Tel: 01895 250230
Case Officer: Cris Lancaster
Email: clancaster@hillington.gov.uk
Date: 2nd July 2020
Our Ref: 47162/PRC/2020/115

RE: Single storey rear extension

SITE: 10 Sherwood Avenue Ruislip

PROPOSED GROUND FLOOR PLAN

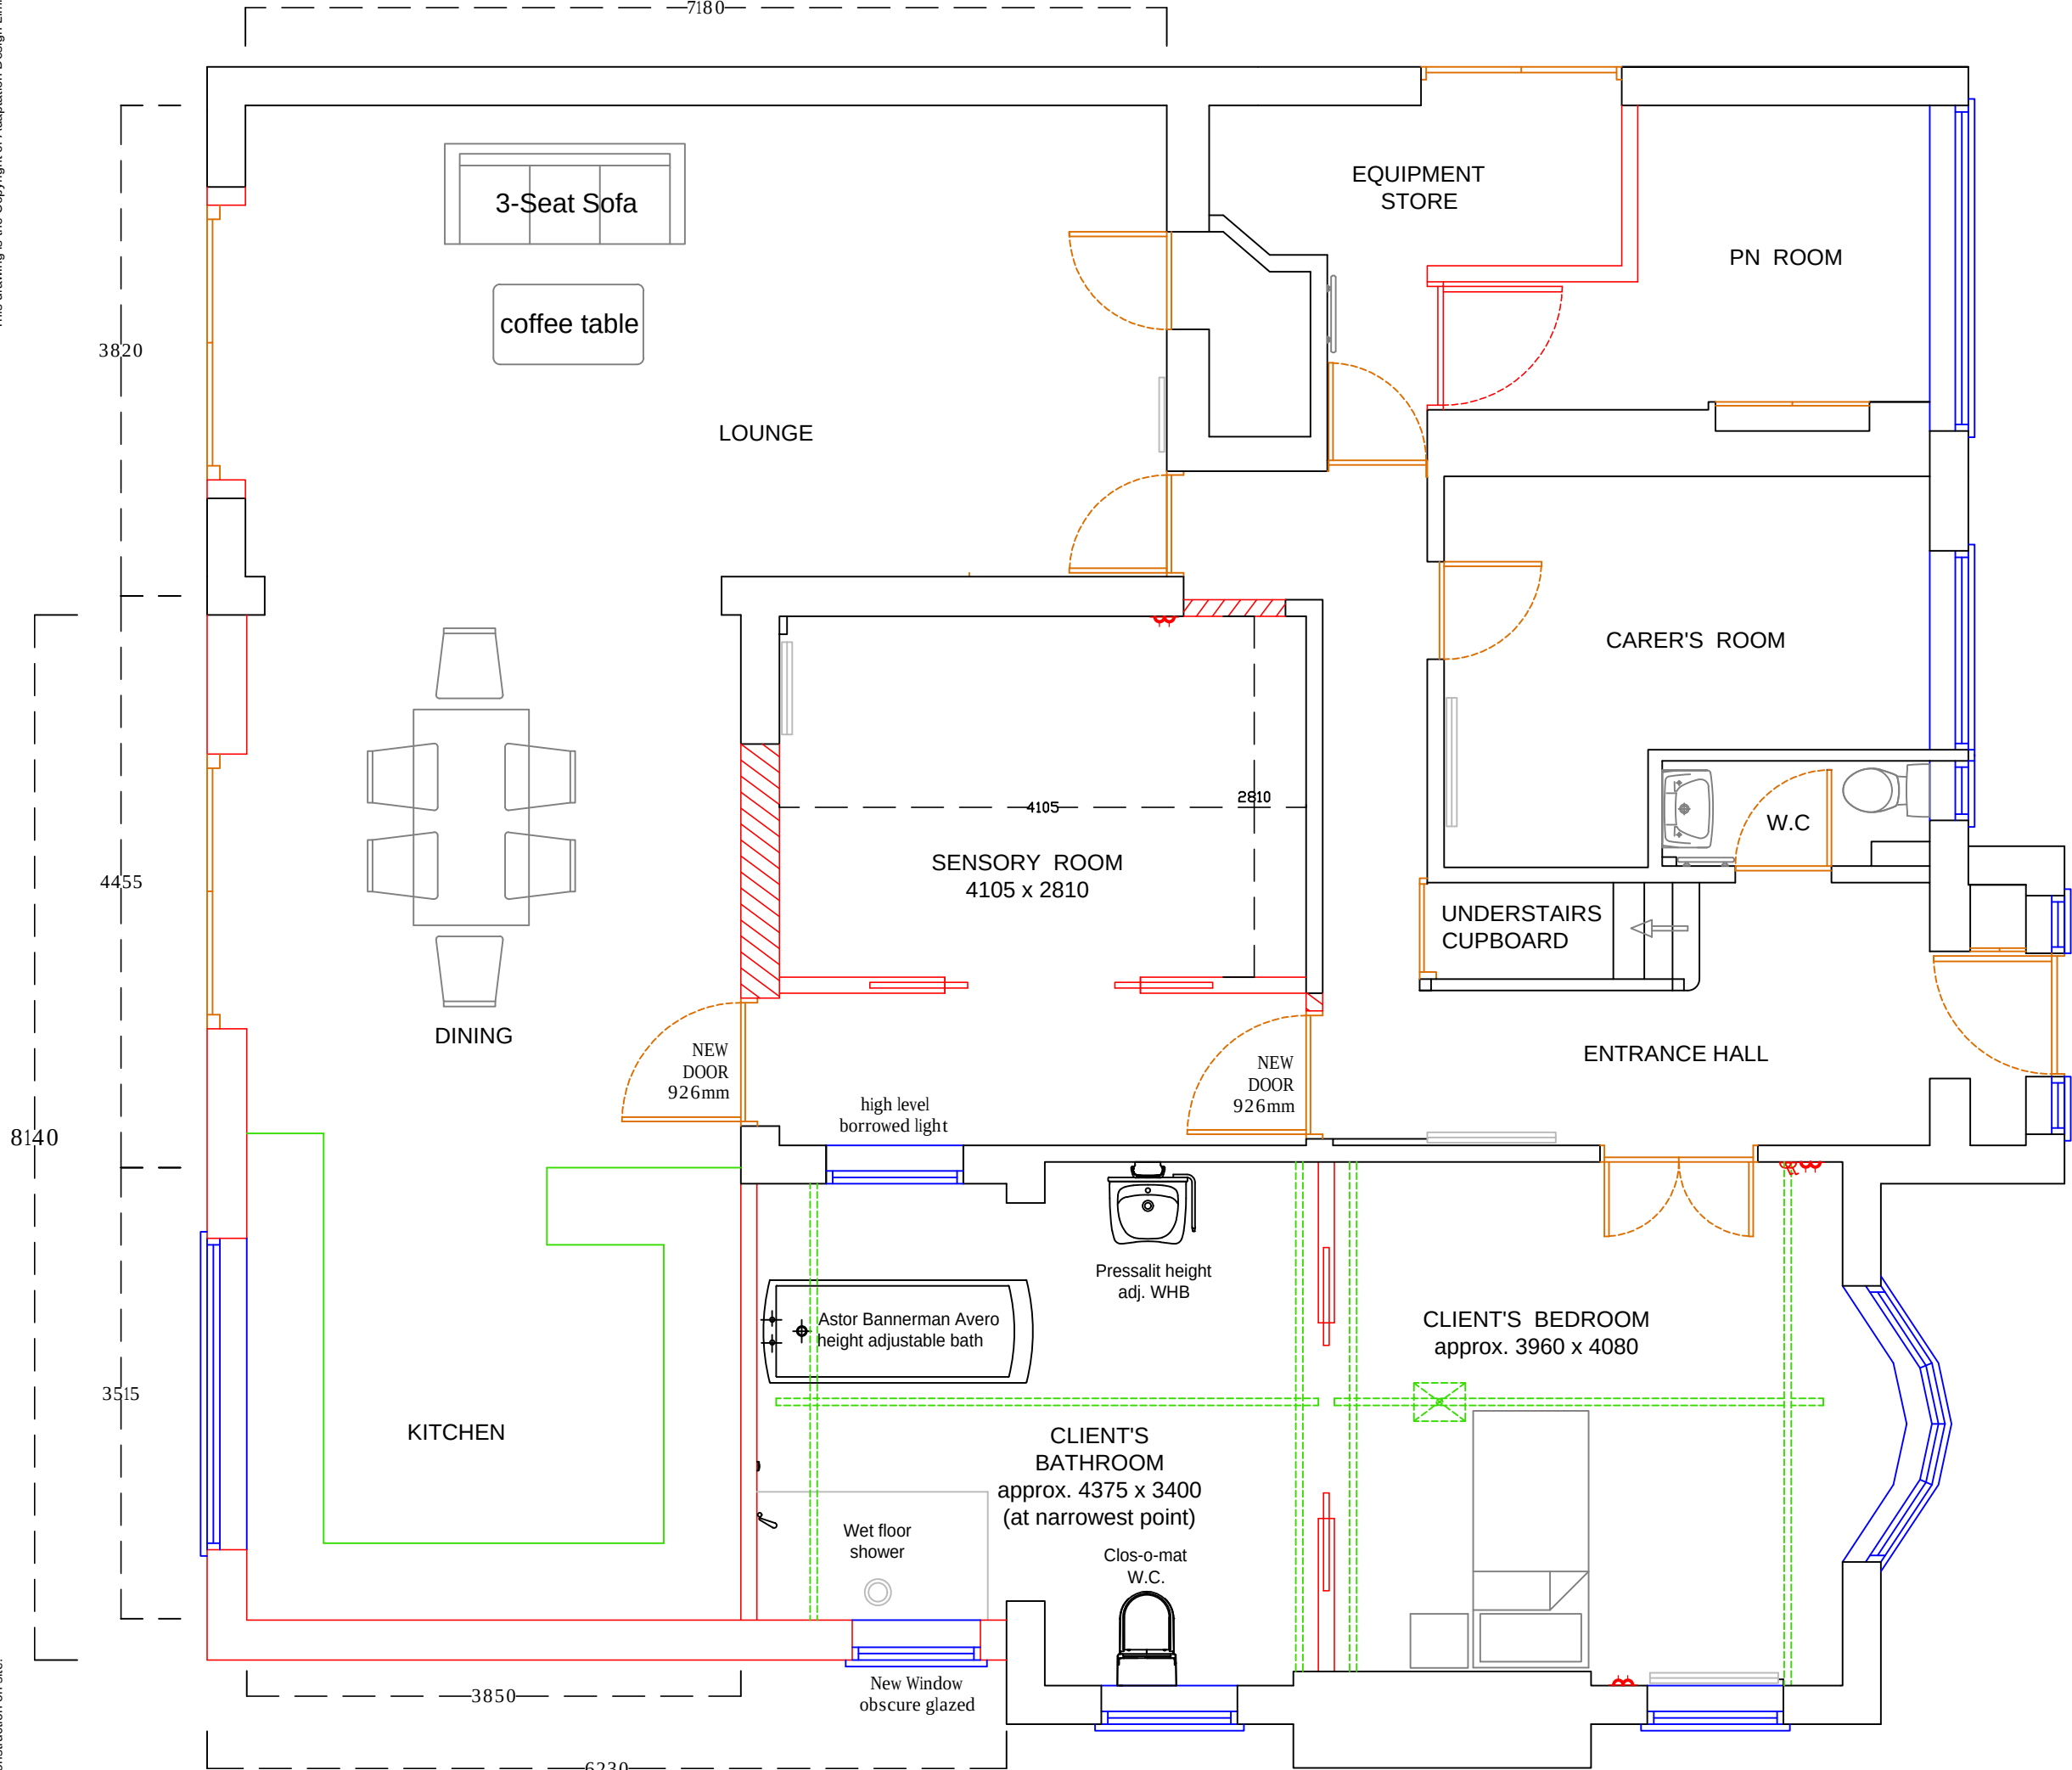
The total rear extension will be 9 metres in depth which significantly exceeds the maximum 4 metres depth set out in Policy DMHD 1. However, it will not be seen from the street or from No. 8 Sherwood Avenue. It is also noted that both No. 8 and No. 10 are deeper on the plot than the current extended dwelling. An existing glass canopy will be removed and the extension will be no deeper than the existing rear extension. The extension is similar to the existing extension in overall form.

It is noted that the proposal includes a live in care team. You do not specify the number of persons or bedrooms required. You also need to clarify whether they will be living as part of the same household since subdivision of the house will require permission in its own right. In this regard you will need to include full floor plans of the dwelling with any submission. These should include an indication of which rooms will be used by the carers.
